DECISION DELEGATED TO HEAD OF PLANNING

Application No: H18-0841-23 **Applicant:** Mr J Lavender
Proposal: Conversion of office to dwelling - Retrospective
Location: Lavender Corner King John Bank Walpole St Andrew
Terminal Date: 25th December 2023

3 3D Isometric Proposed

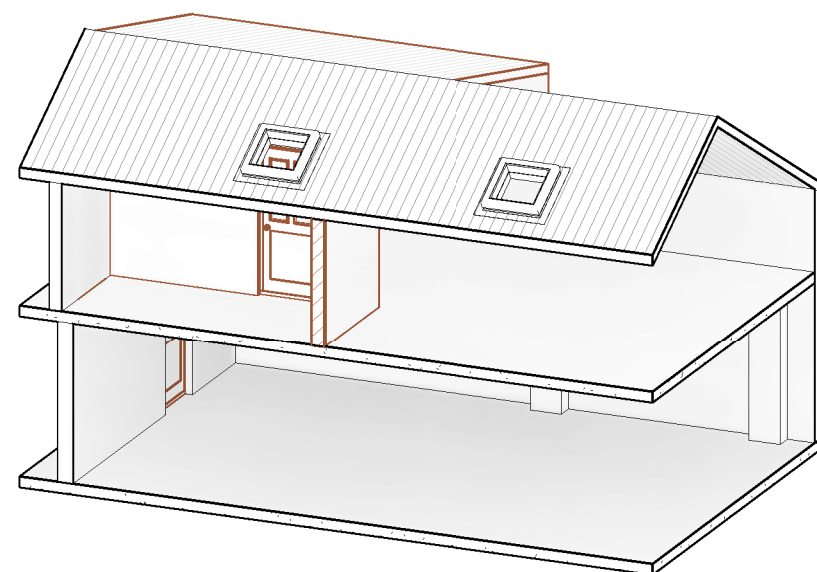
The proposal is not considered to constitute a sympathetic conversion of a curtilage building and will lead to a residential use and design out of keeping with other residential properties in the vicinity of the site.

It is considered that the proposed design and layout constitutes a cramped and incongruous form of development that will have a material impact on the character and appearance of the surrounding area. No pre-application advice was sought prior to submission of the application and this is considered to be reflected in the proposed design. The design is not reflective of a countryside vernacular dwelling and does not appear to follow a defined architectural style. The separation distance of the dwelling to the existing dwelling at Lavender Corner is 4.5 metres at the nearest point. This is not considered to accord with the well spaced, linear development along King John Bank

TITLE	Proposed Plans
-------	----------------

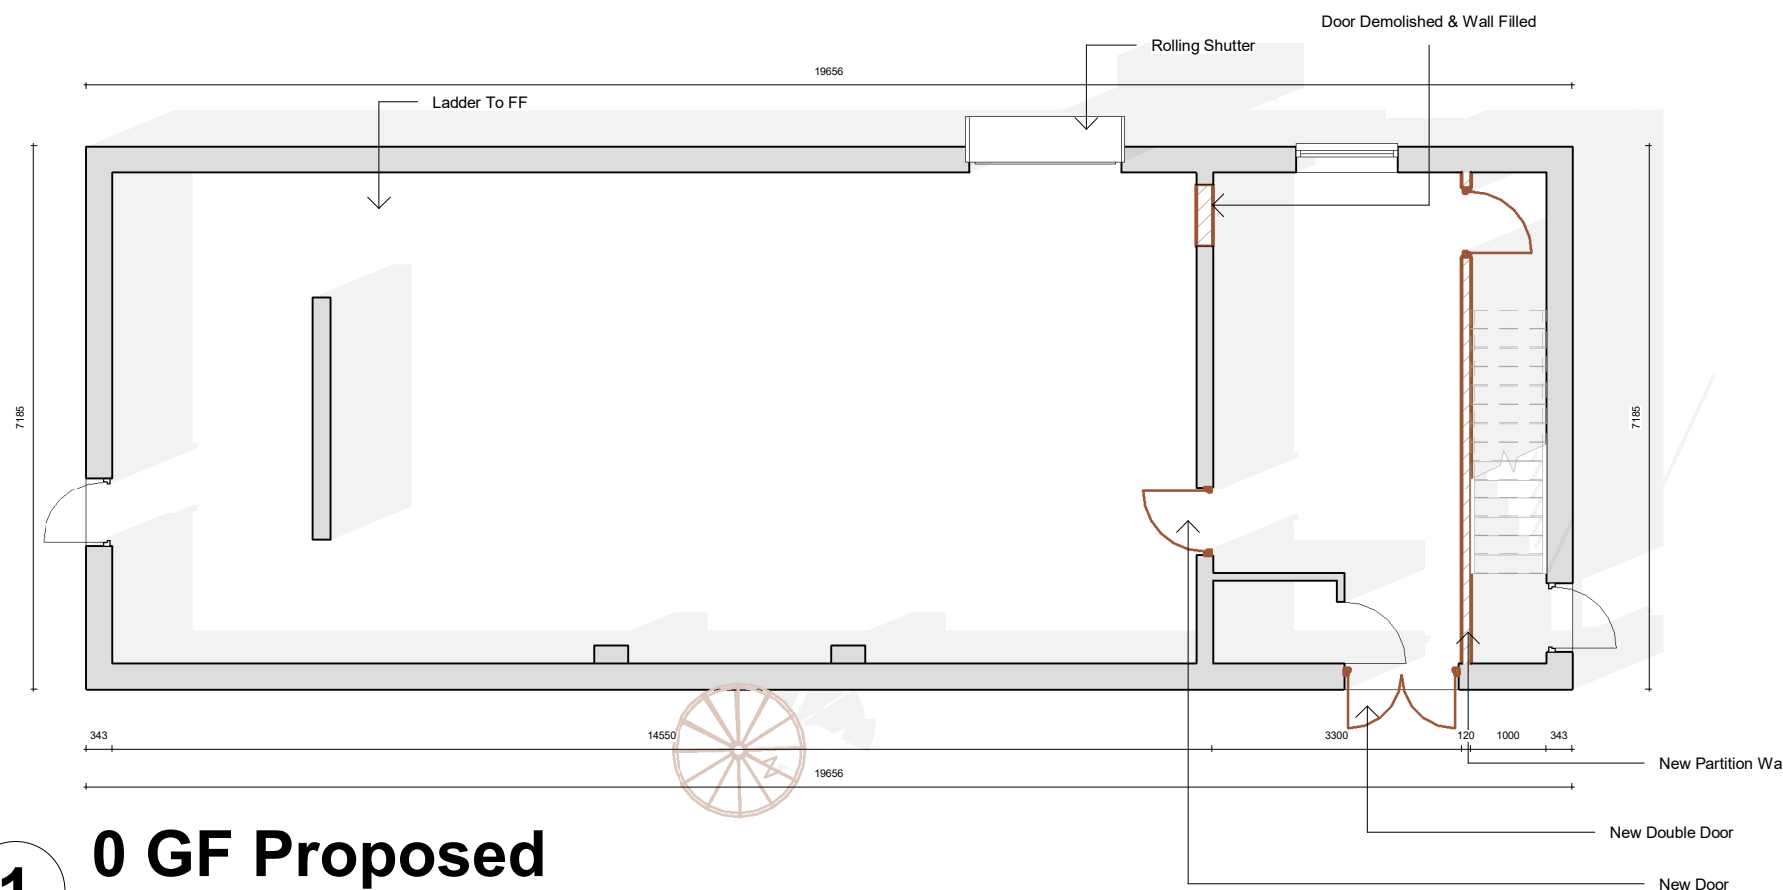
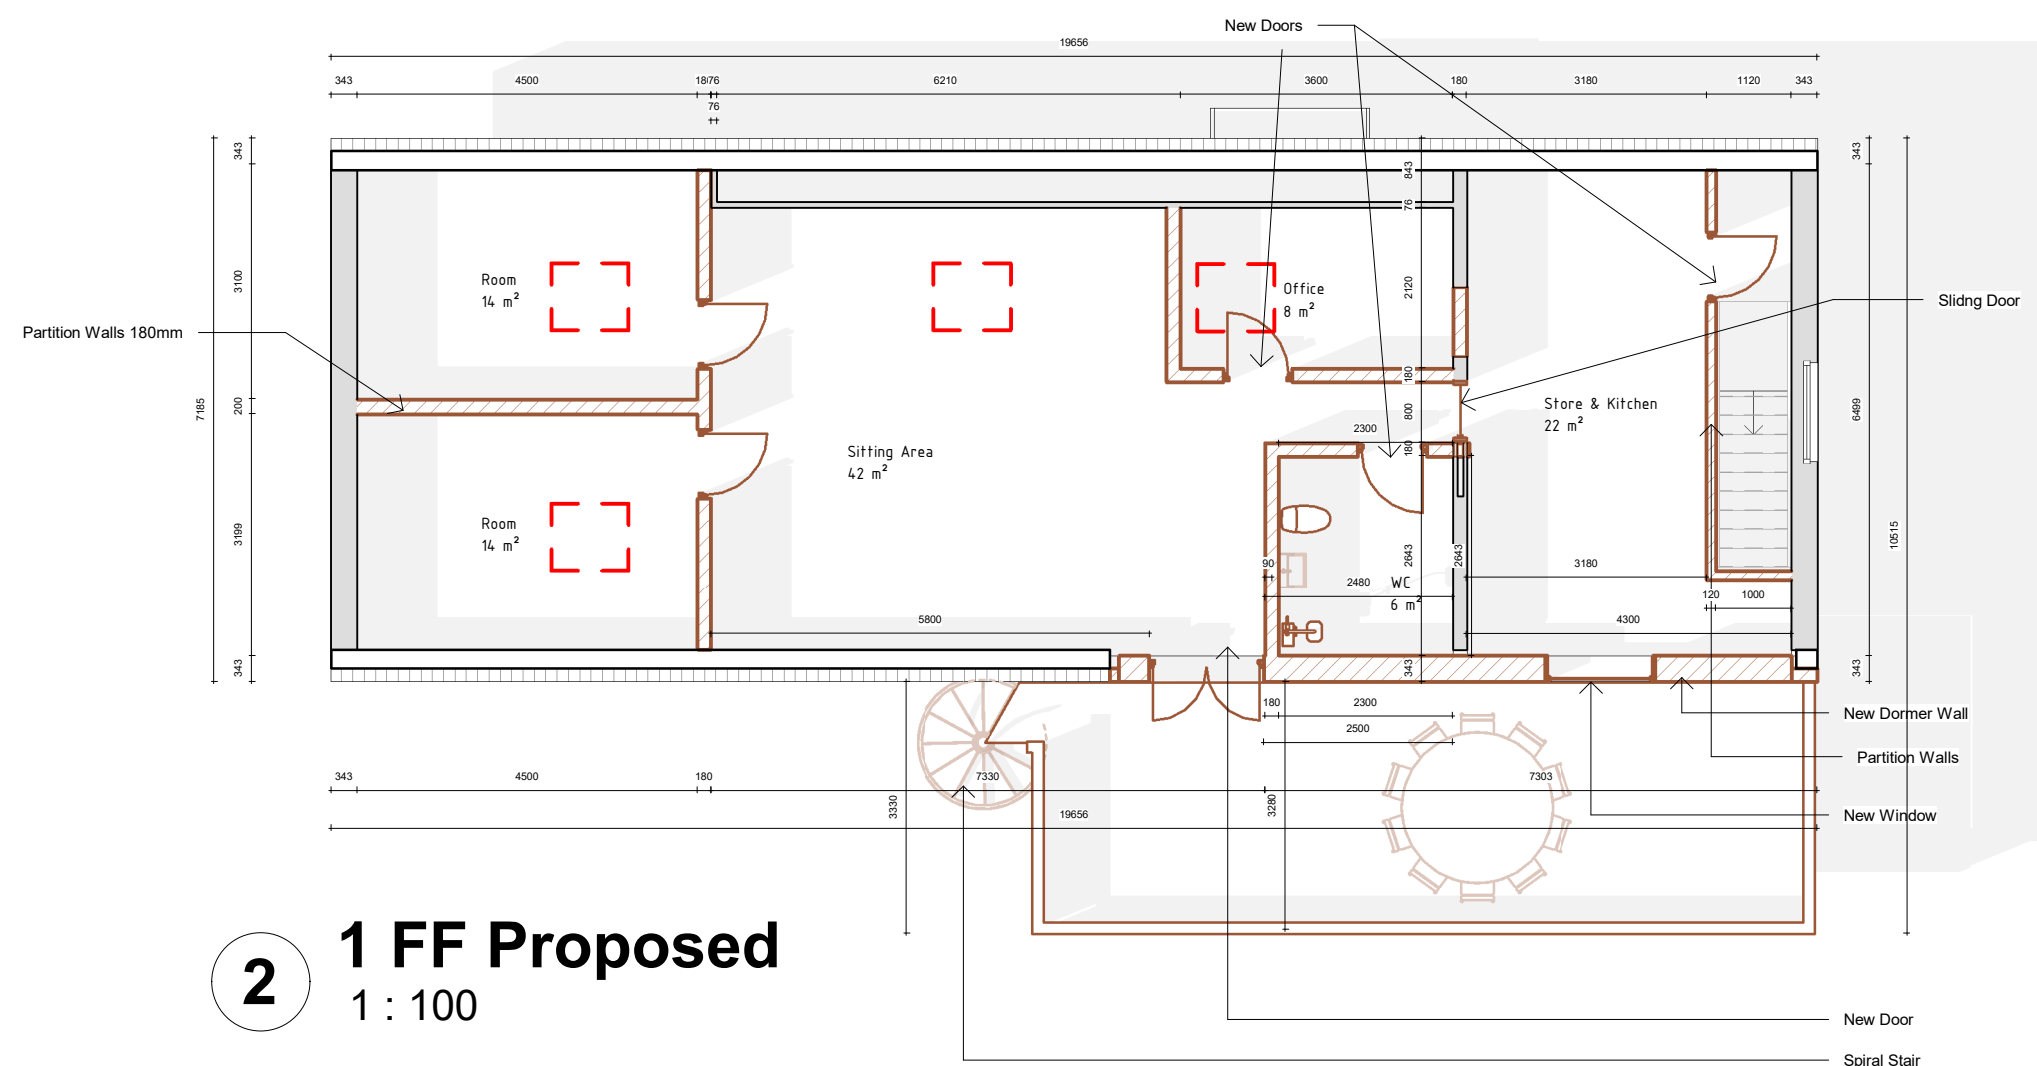
This is a partially retrospective application for the conversion of an office to a dwelling at Lavender Corner, King John Bank, Walpole St Andrew. The proposal seeks to make minor internal alterations at ground floor level as well as a ground floor level rear elevation door. The ground floor level will not be used for habitable rooms. At first floor level two bedrooms, a sitting area, office, bathroom and combined store / kitchen will be provided. A new window will be sited in the rear elevation of the store / kitchen room. The area of the roof space above the store / kitchen and sitting area has been extended in height by a slope dormer to allow access to the terrace. The slope dormer is constructed from timber cladding.

This floor will be accessed via an existing internal staircase. An external first floor terrace will be provided to the rear south-west facing elevation. This partially constructed terrace will be 10.34 metres in width, project 3.33 metres from the rear wall. The terrace will be accessed via doors from the sitting area as well as an external spiral staircase to the side of the balcony measuring 1.75 metres in diameter. The finished floor level of the terrace is set at 2.4 metres above ground level. Materials of construction for the terrace have not been submitted but the structure of the terrace was observed to be metal. The works that have already taken place are in compliance with the previously approved application H18-0863-22 for extensions and alterations to the office building and dwelling.

The proposal is considered to constitute overdevelopment. No private amenity space has been allocated to the dwelling and no clarity has been given as to the use of garden space to the rear of the proposed dwelling.

There is considered to be a material overshadowing from the proposal. Whilst the building in which the dwelling is to be contained is already on site, the installation of a terrace is located over a garden in the ownership of Lavender Corner. Therefore a terrace is under construction on and above garden space that it utilised and owned by another dwelling.

There is considered to be a material overlooking impact from the proposal. Whilst the frontage windows on the north elevation overlook a drain and road, there is considered to be a material overlooking impact from fenestration on the southern rear elevation. The window on the eastern side elevation serves a staircase and directly faces the predominately glazed conservatory to the northern side elevation of Lavender Corner, which is 11.6 metres away. This is considered to constitute a material overlooking impact, albeit not from a habitable room. The doors, windows and first floor terrace of the southern rear elevation are 13.7 metres away from Lavender Corner at the furthest point, and 4.5 metres away at the nearest point. The rear elevation terrace, doors and windows offer material overlooking views over the garden, swimming pool and north-west facing rear elevation windows of Lavender Corner. The ground floor western side elevation door faces the established 3 metre hedging on the western boundary. There is not considered to be an overlooking impact from this door.
